**Application by Rosefield Energyfarm Ltd. For an Order Granting Development
Consent for Rosefield Solar Farm
NSIP Reference: EN010158**

**Natural England's Response for Deadline 5
Examining Authority's submission deadline: 29 July 2026**

Annex 1: Natural England's comments on any further information received

TITLE:
APPENDIX 5A
GREEN AND BLUE INFRASTRUCTURE PARAMETERS
BUFFER WIDTHS - KEY PLAN

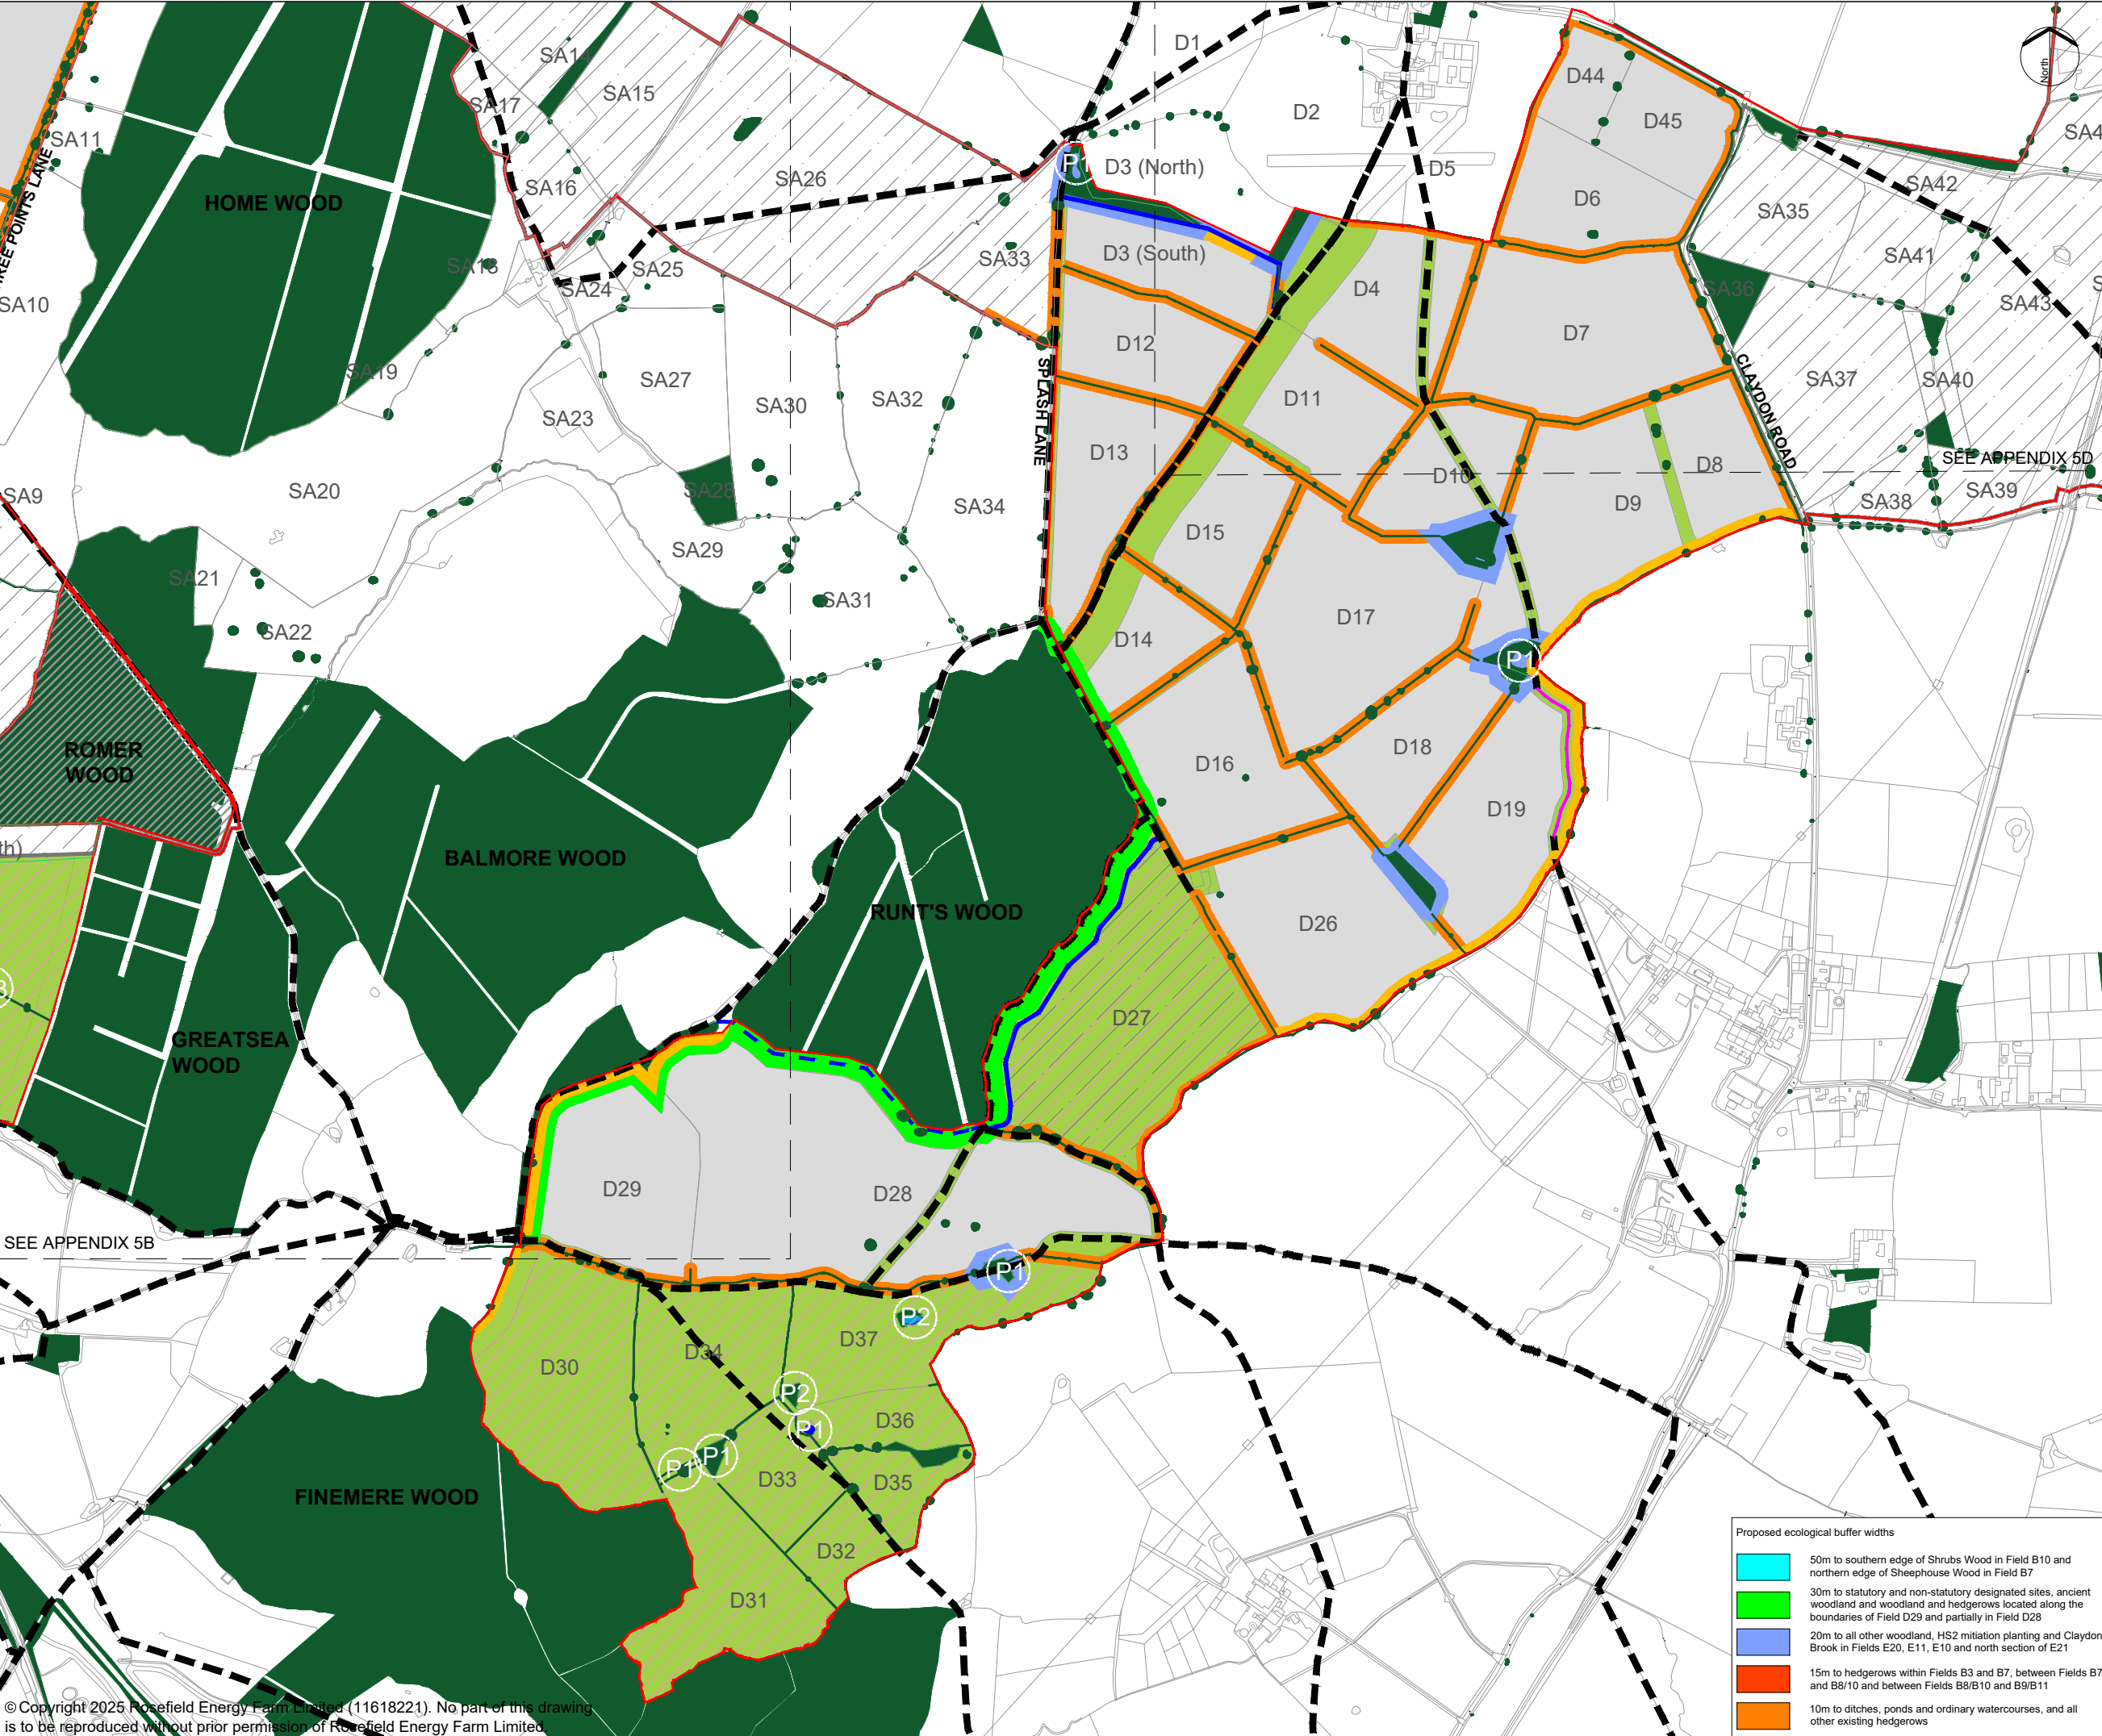
3.14.8	Size of buffer zones	While the Applicant has accepted our points regarding technical and hypothetical distances of echolocation, they have maintained that 15m (from the centreline of existing hedgerows) is appropriate.

Table Ref	Topic	NE Comment
		There is, currently, no way of knowing what is adequate in terms of buffer size, as we don't know over what distance an avoidance effect is elicited. We advise the additional area of land retained additional to the feature of interest is maximised, so that the value of that feature is being maintained not eroded. The total corridor free of solar panels may be 40m when measured from panels one side, but as you reach the far side of the buffer you are in direct proximity to panels the other side. This is the issue, the hedgerows are being 'squeezed' between fields of solar arrays, where currently there are open habitats. So, it makes sense to measure from the edge of the feature being protected so that the entirety of that feature is given the minimum distance from the object being avoided. If you do this, narrower features end up being over all a narrower swathe of habitat, wider features end up comprising a wider swathe of habitat. Measuring from the centreline means that buffers are not additional to the feature and will only ever be the maximum distance panels are from the feature. In effect this will serve to minimise the width of the feature, and every hedgerow across the project area essentially becomes 0m wide, it does not matter if they are currently a narrow or a wide hedgerow, and the widest hedgerows will be subject to more of a 'squeezing' effect than narrow ones. At this stage of the examination, we have accepted that there is a fundamental difference of opinion between Natural England and the Applicant. We hope that we have explained our advice as best we can in order to enable the Examining Authority to make an informed recommendation on the implementation of ecological buffers across the site.

Removal of Solar in B6, B7 & B8

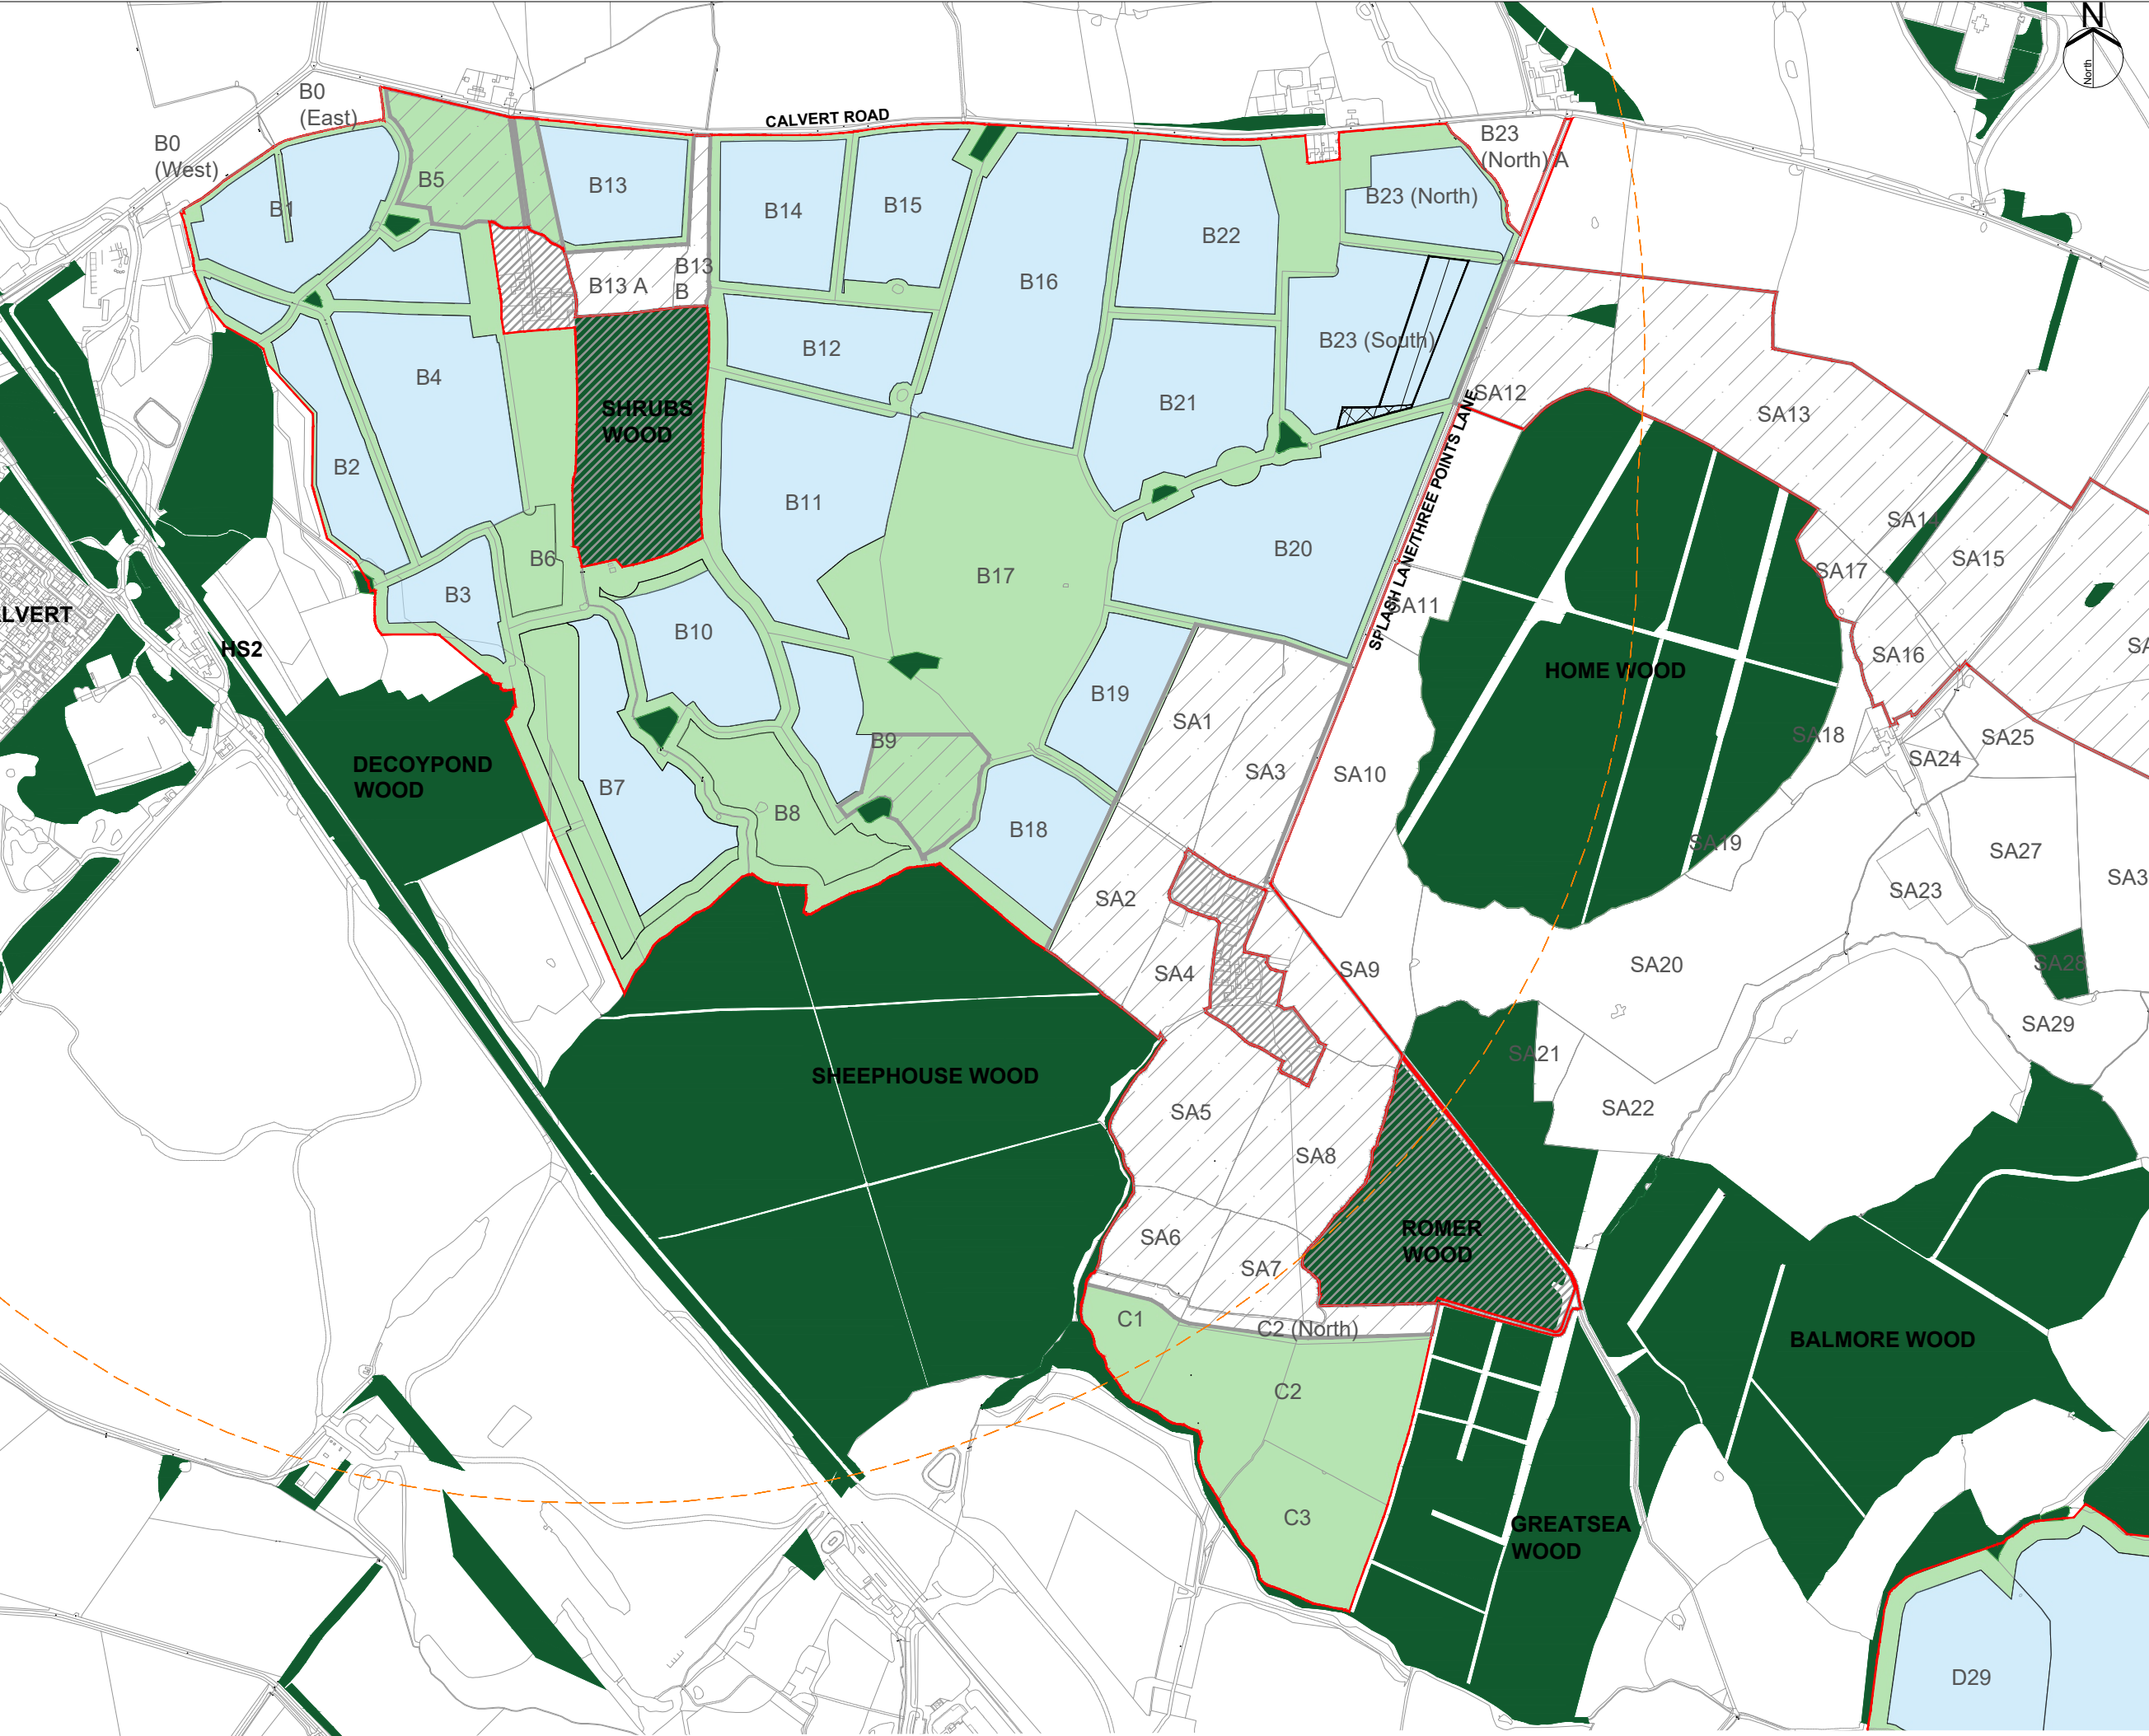
ExQ2	NE Comment
Q2.5.4	Bechstein's bat – potential loss of foraging habitat As indicated in Annex 1 of this response, Natural England have reached provisional agreement on fields B3, B6, B7 and B8. In the amended scheme design, panels have been removed from a number of fields which we have raised in our concerns, and in others the panel allocation has been scaled back in order to reduce potential impacts to Bechstein's bat. Subject to confirming that the documents submitted at Deadline 5 accurately reflect what we have reviewed, Natural England considers that the proposals should resolve its outstanding concern regarding potential effects on Bechstein's bats through the loss of foraging habitat.
Q2.5.6	Bechstein's bat – potential impacts from construction Natural England are broadly in agreement that the proposed construction compounds are unlikely to cause a negative impact on Bechstein's bat provided the development proposal is carried out in accordance with the measures discussed in the Applicant's response. We recommend that the construction compound is located in field B10, as far away from boundary features as possible, and that a compound in B3 is avoided.
